**AOWE ATO INSTALLATION REPORT**

December 26, 2024

RE: Cedar Point Subdivision Lot 5- Installation Revision- Pump Tank and Pressure Manifold Added  
126 Deodora Lane Cameron NC 28326  
PIN: 9574-21-0401

Cedar Pointe Lot 5 :: Septic Layout Detail

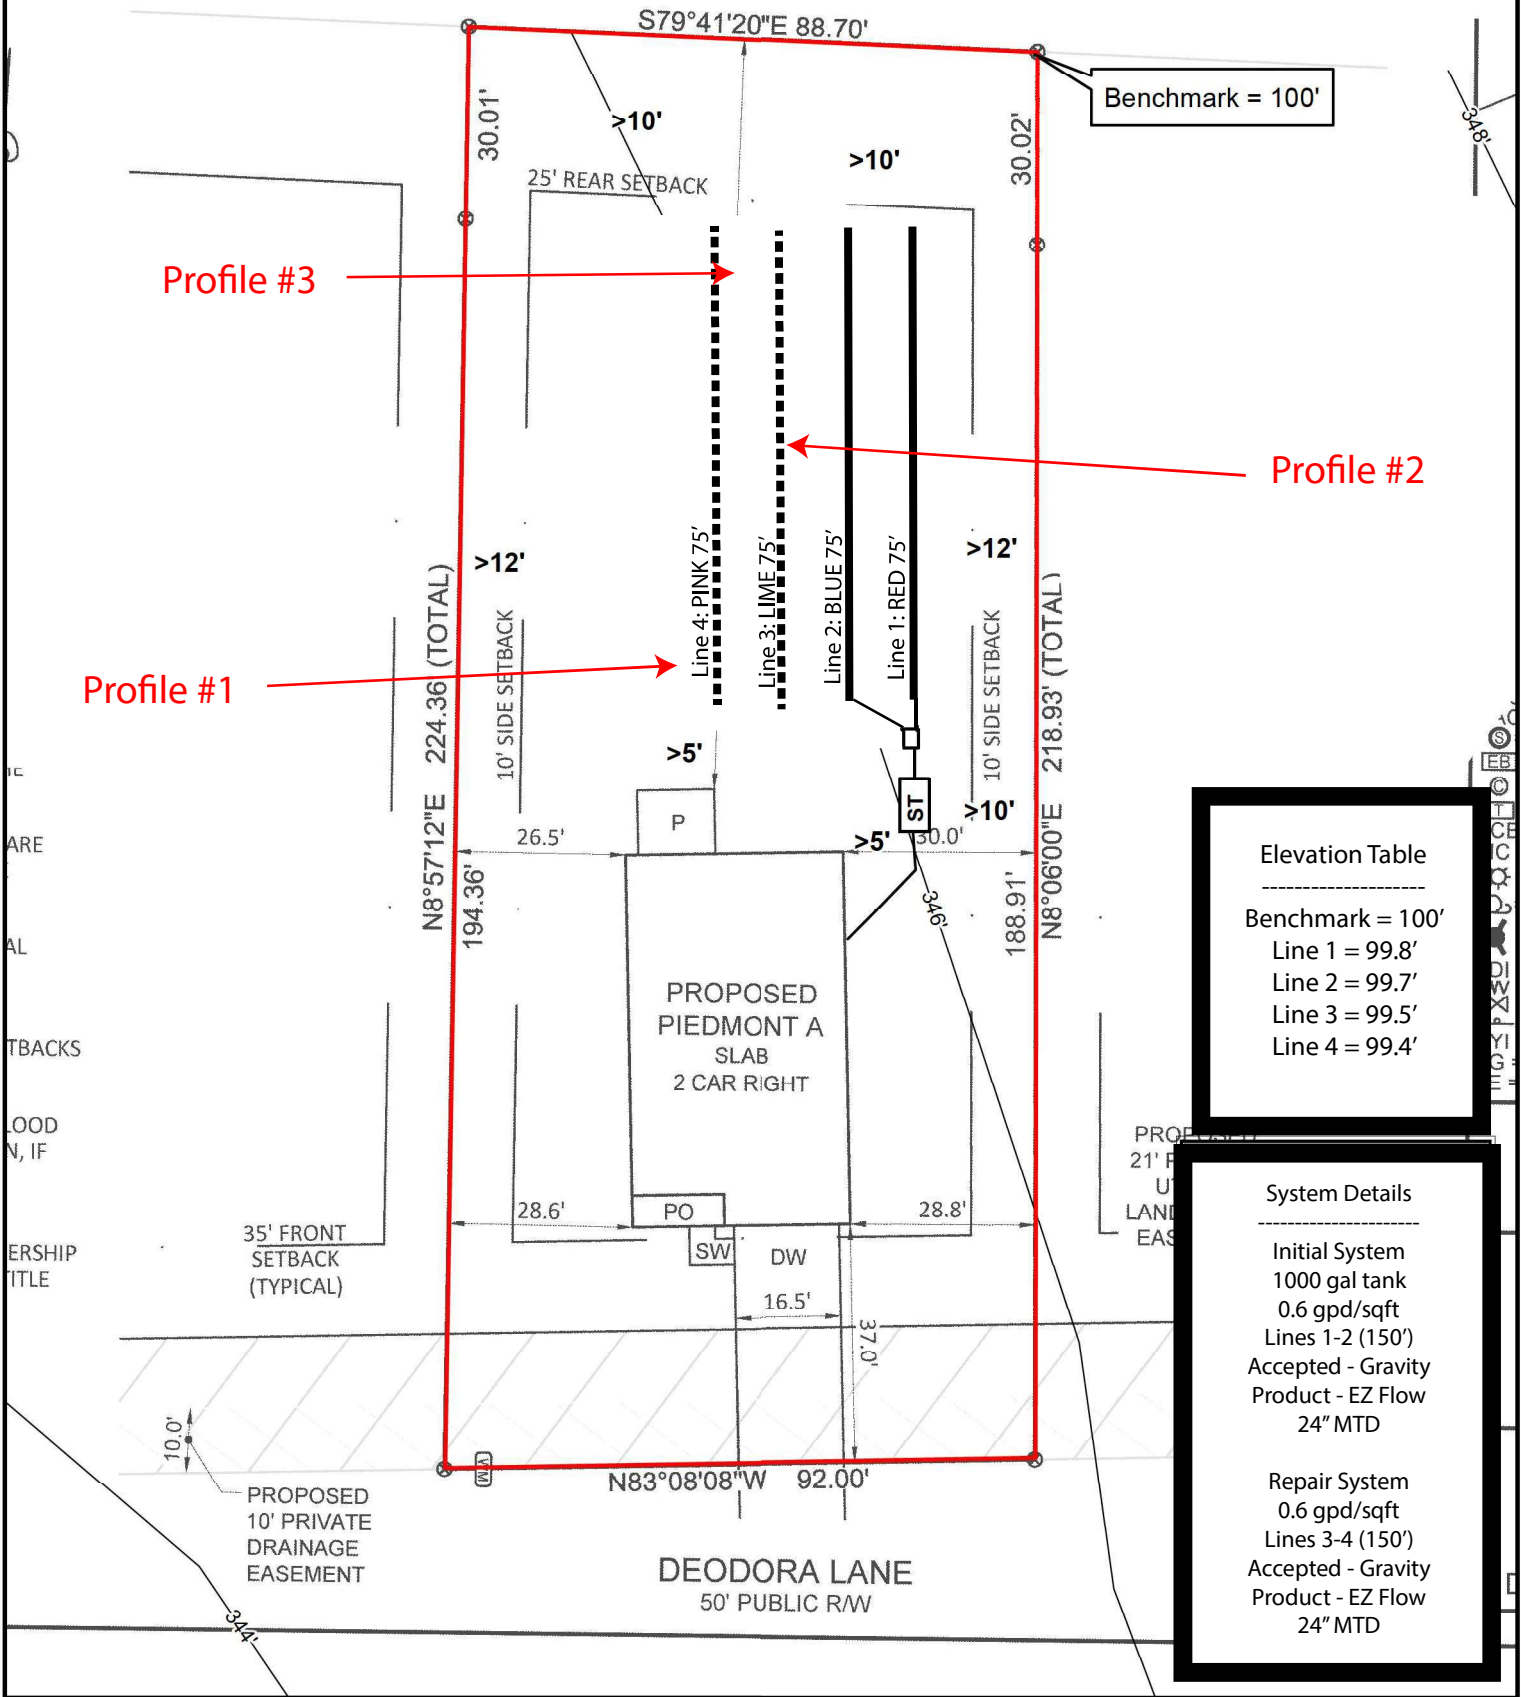
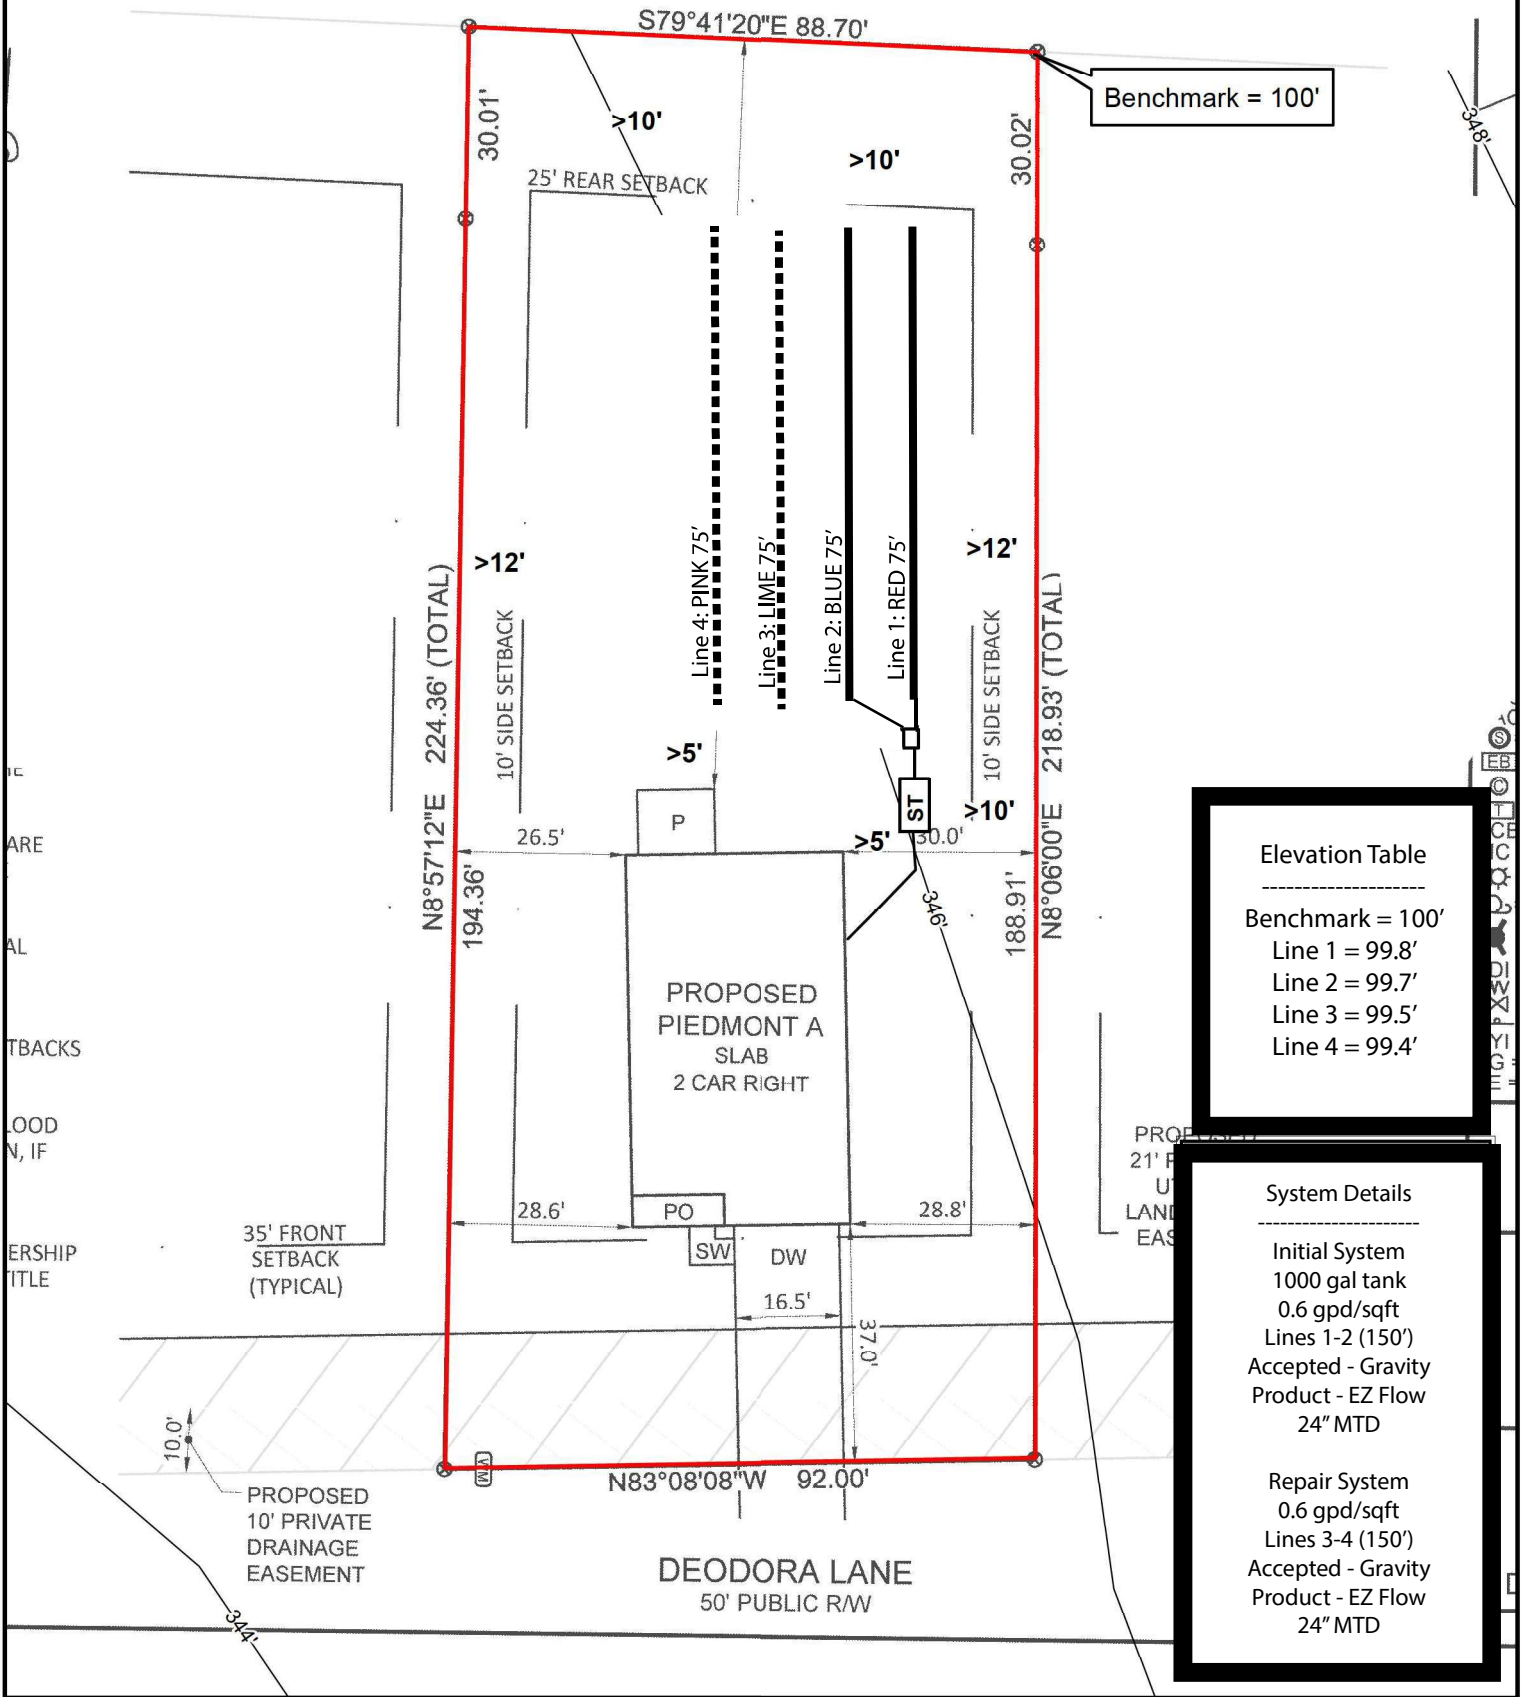
Program Supervisor, Mark Osburne, REHS Harnett County Health Department:  
The plumbing stub was installed too deep for the trench depth specification to be met at Cedar Point Lot 5, so a pump tank and pressure manifold were added by the installer. See the attached 'as-built' revision diagram and pressure manifold tap sheet.  
Please let me know if you have any questions,

System Details	
<b>Initial System:</b>	
1000 gal Septic Tank	
1000 gal Pump Tank	
0.6 gpd/sqft	
Lines 1-2 (150')	
Accepted - Manifold	
Product - EZ Flow	
35" MTD	
<b>Repair System:</b>	
1000 gal Septic Tank	
1000 gal Pump Tank	
0.6 gpd/sqft	
Lines 3-4 (150')	
Accepted - Manifold	
Product - EZ Flow	
35" MTD
